From: Sue Howell <Sue.Howell@arun.gov.uk>
Sent: 15 February 2022 18:31
To: Planning.Responses <Planning.Responses@arun.gov.uk>
Cc: Anita Gardner <Anita.Gardner@arun.gov.uk>
Subject: Planning Consultation on: LU/338/21/PL

Response to Planning Application

Application ref: LU/338/21/PL

Description: Construction of a Youth and Community Centre, Multi Use Games Area (MUGA), Cycle Store, Bin Store, vehicular access and altered pedestrian access with associated scheme of hard and soft landscaping.

PROPOSED MUGA

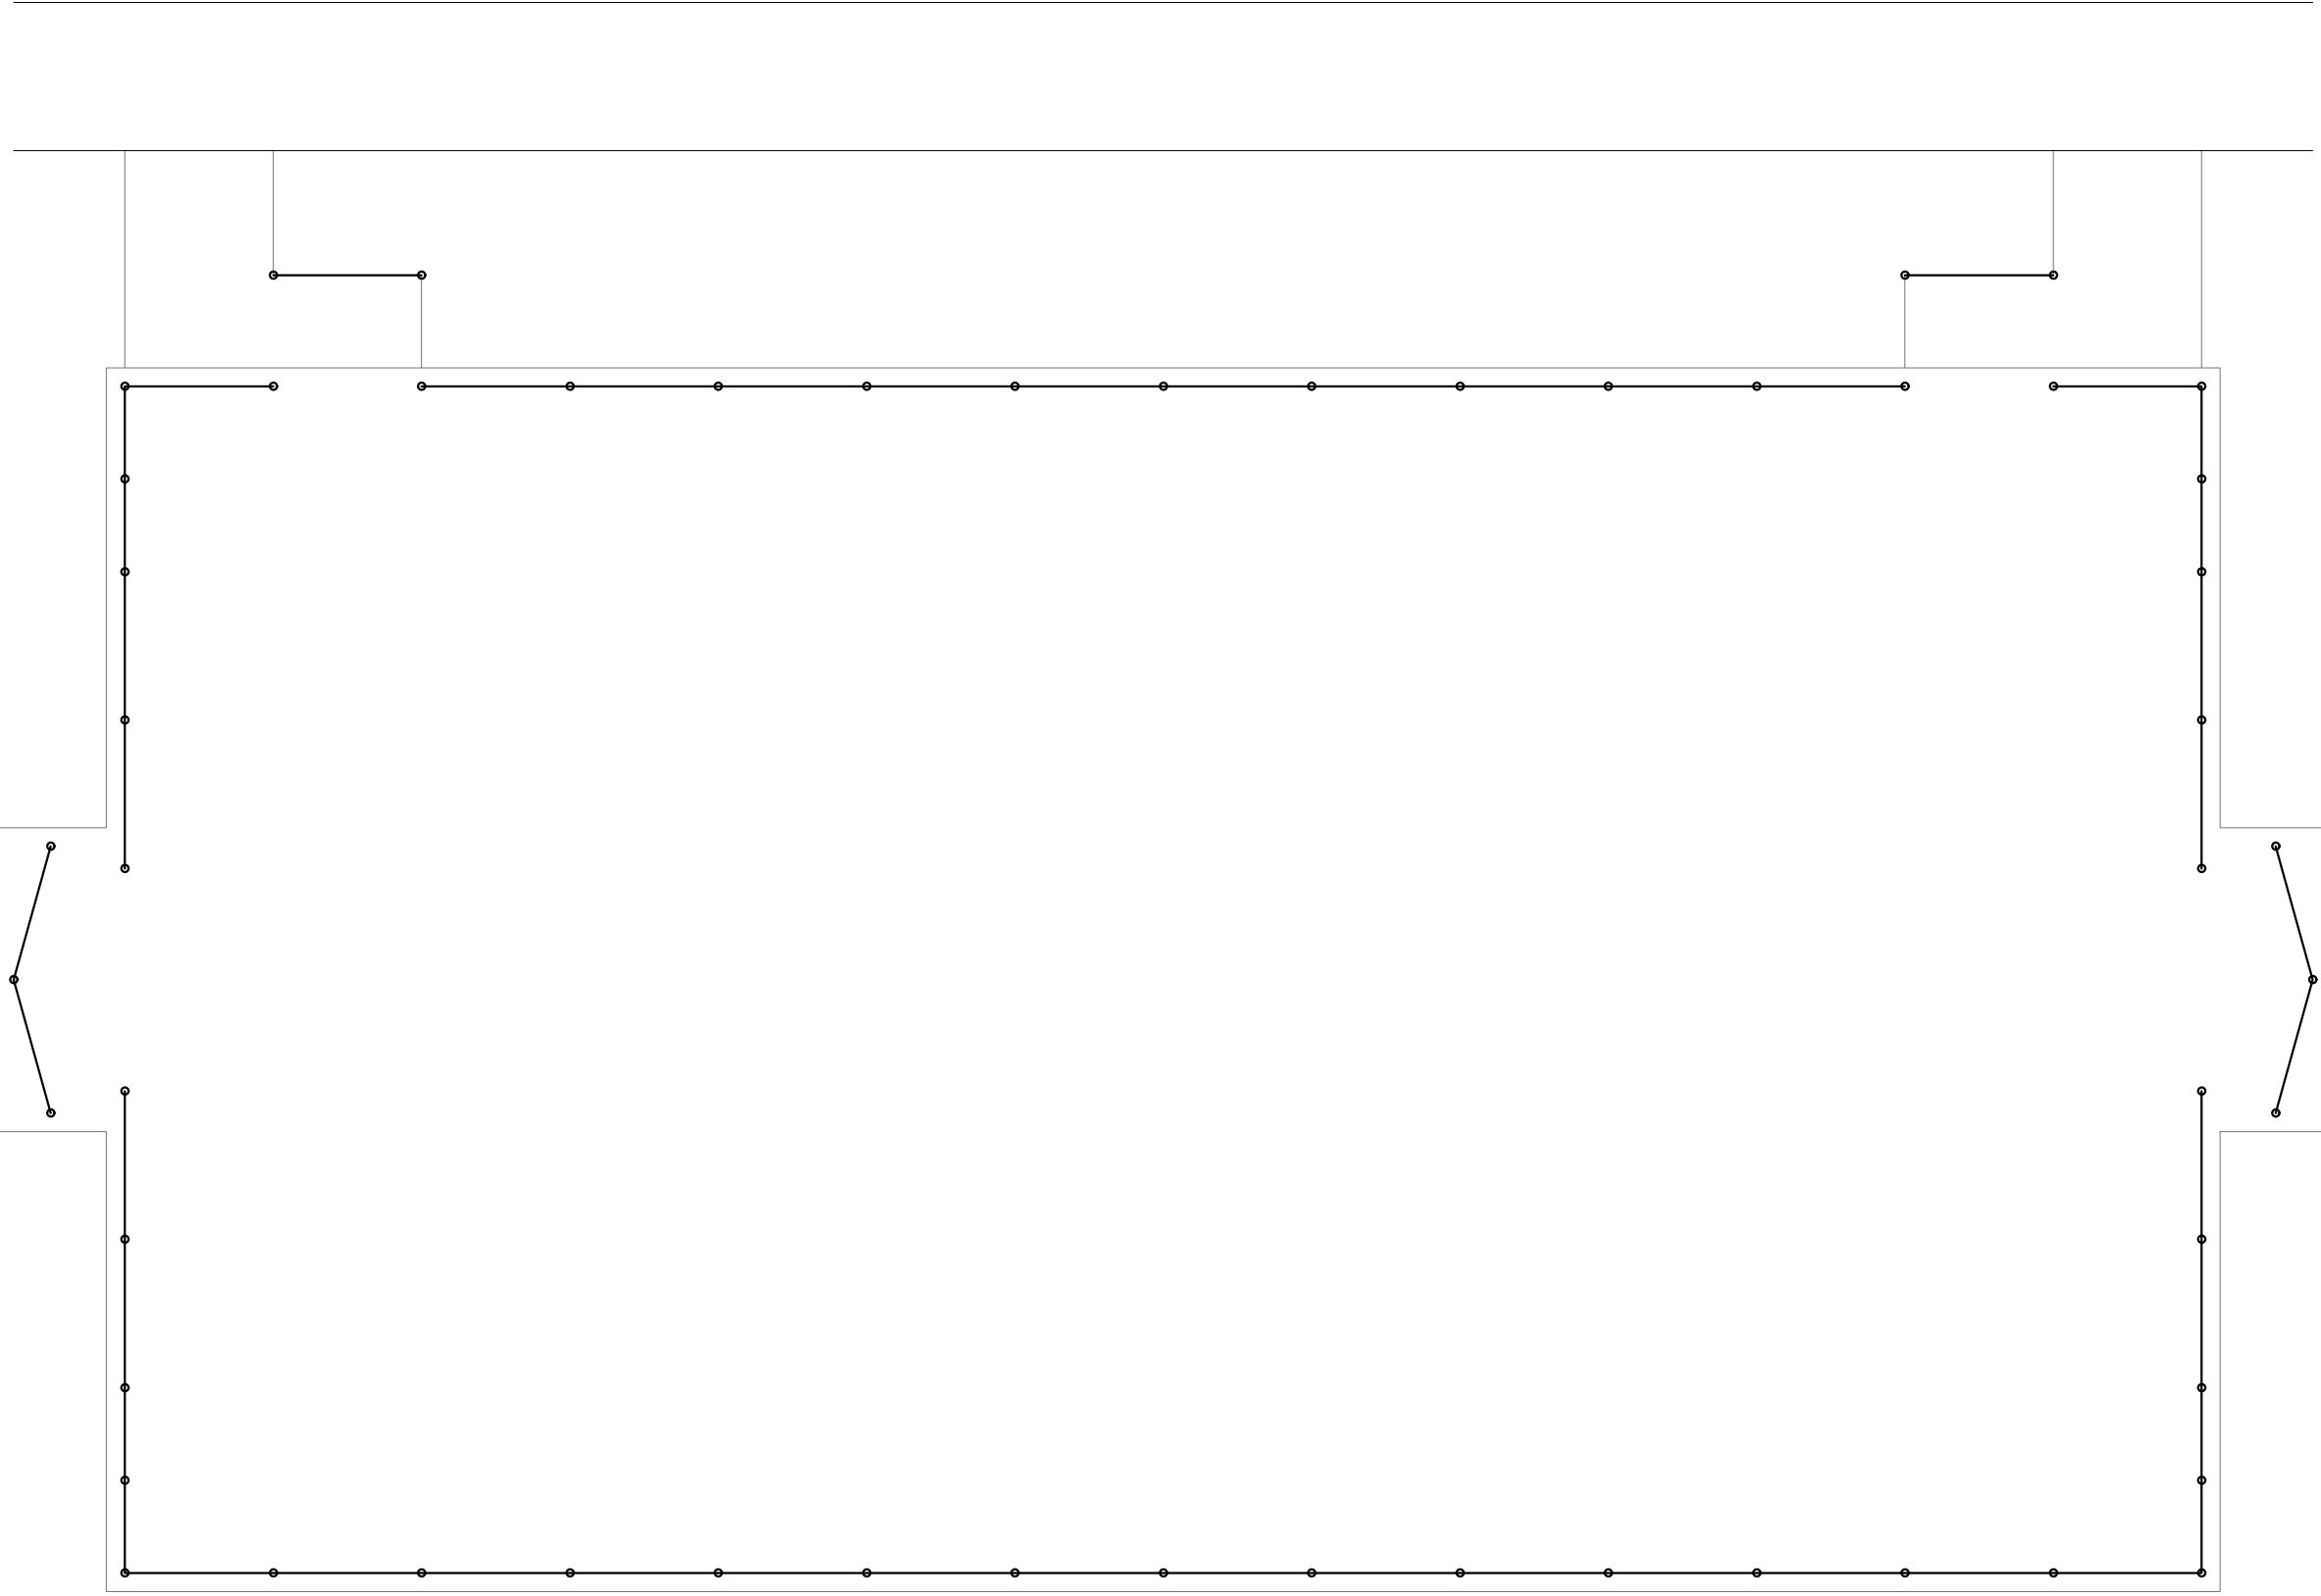
The proposed MUGA is detailed to be surfaced with permeable asphalt and would be fenced with min. 3.0 m high robust sports fencing. Positioning of MUGA would be in line with Sport England's Design and Construction Considerations. At its closest point, the proposed MUGA would be 26.5 m from nearest residential dwelling.

BLOCK PLAN
1:500

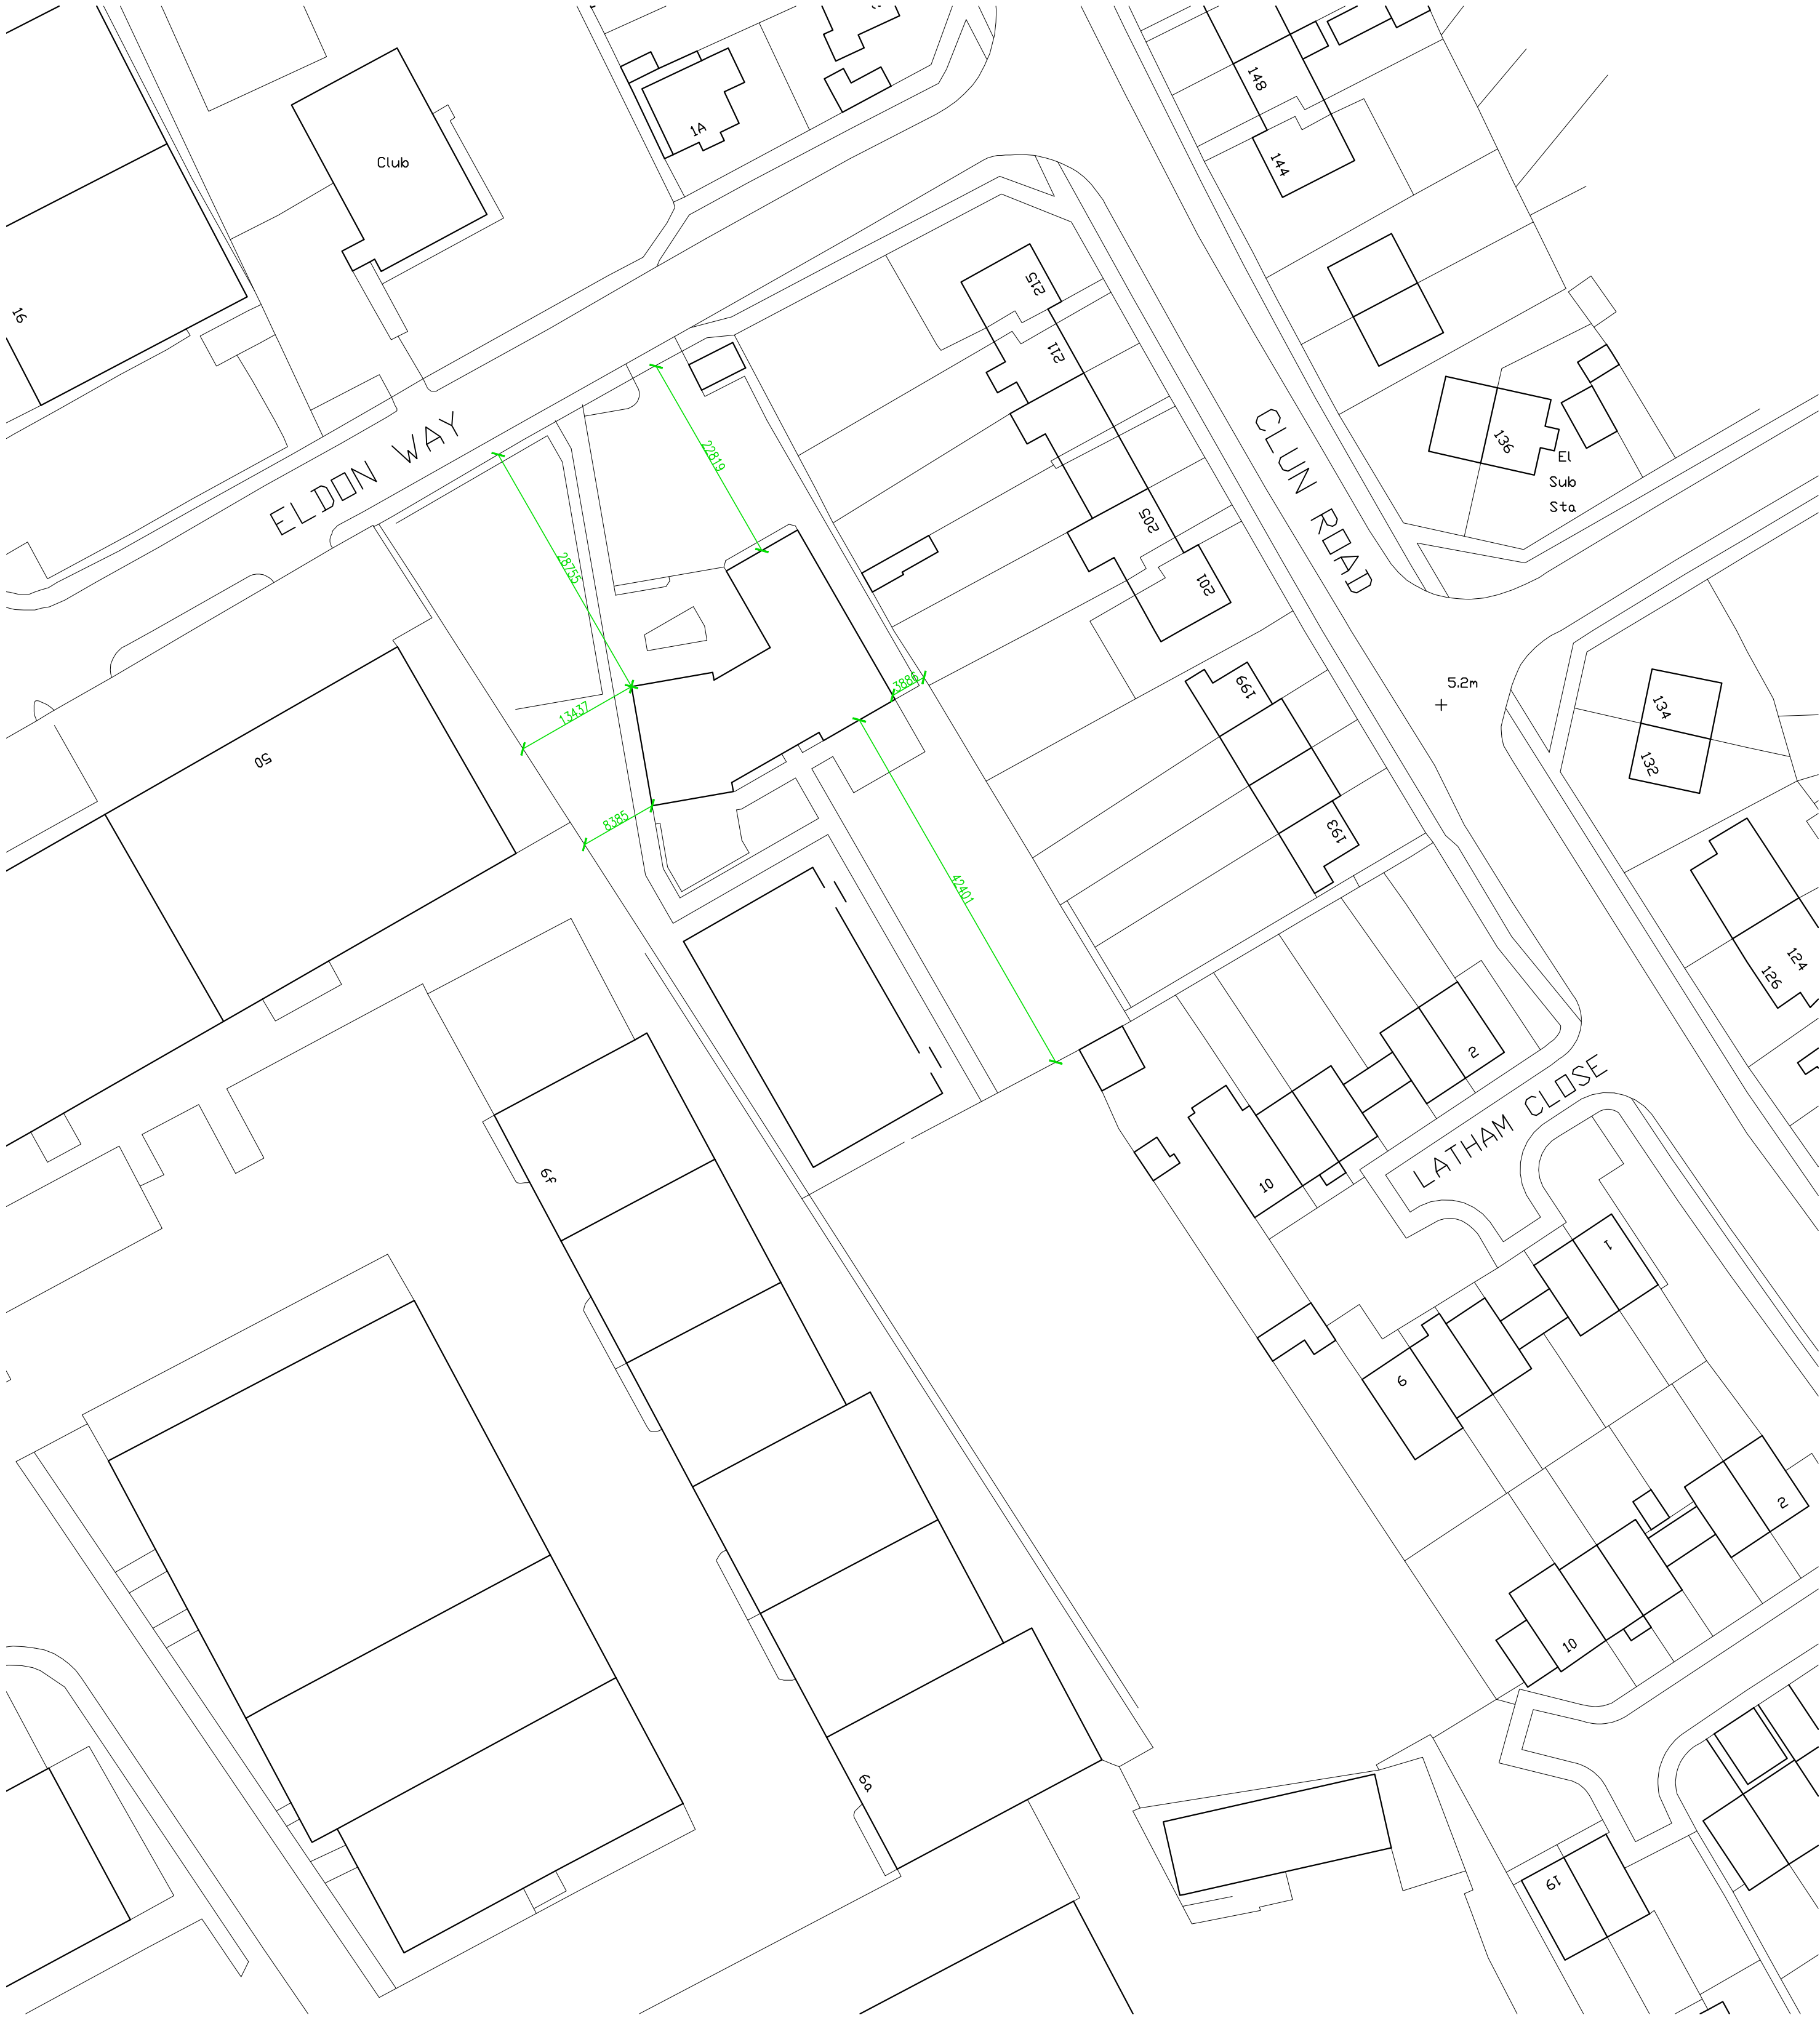
The replacement play area and proposed MUGA are to be located close to the sites western boundary, which adjoins industrial units rather than residential dwellings and has been set in consideration of Aruns Design Guide 2021.

The potential impact of the proposals, could be blended into the surrounding environment with further thought given to the landscape offer and greening to counteract this. Screening to adjacent properties should be considered because of the proximity of the proposals.

Further landscape provision to the boundaries and accessible areas and incorporation of screening to adjacent properties with the incorporation of planted areas for trees and shrubs. The green boundary treatment to include tree species. All areas should be considered and their connection for biodiversity and habitat explored. Trees specified should be at a size which allow instant impact, but which will establish and mature as the site develops.
